## EL PASO COUNTY GRADING AND EROSION CONTROL PLAN CHECKLIST

EPC Project Number: PPR-22-044

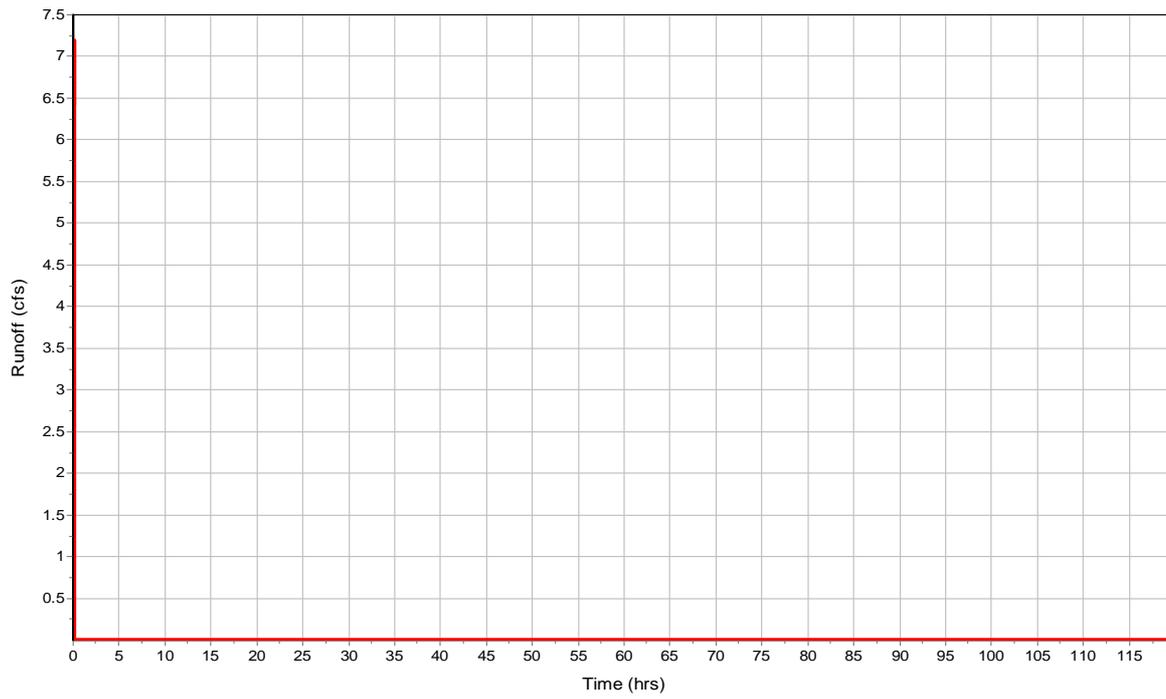
v	All proposed temporary construction control measures, structural and non-structural. Temporary construction control measures shall be identified by phase of implementation to include "initial," "interim," and "final" or shown on separate phased maps identifying each phase		✗
w	Vehicle tracking provided at all construction entrances/exits. Construction fencing, barricades, and/or signage provided at access points not to be used for construction		✓
x	Temporary sediment ponds provided for disturbed drainage areas greater than 1 acre		✗
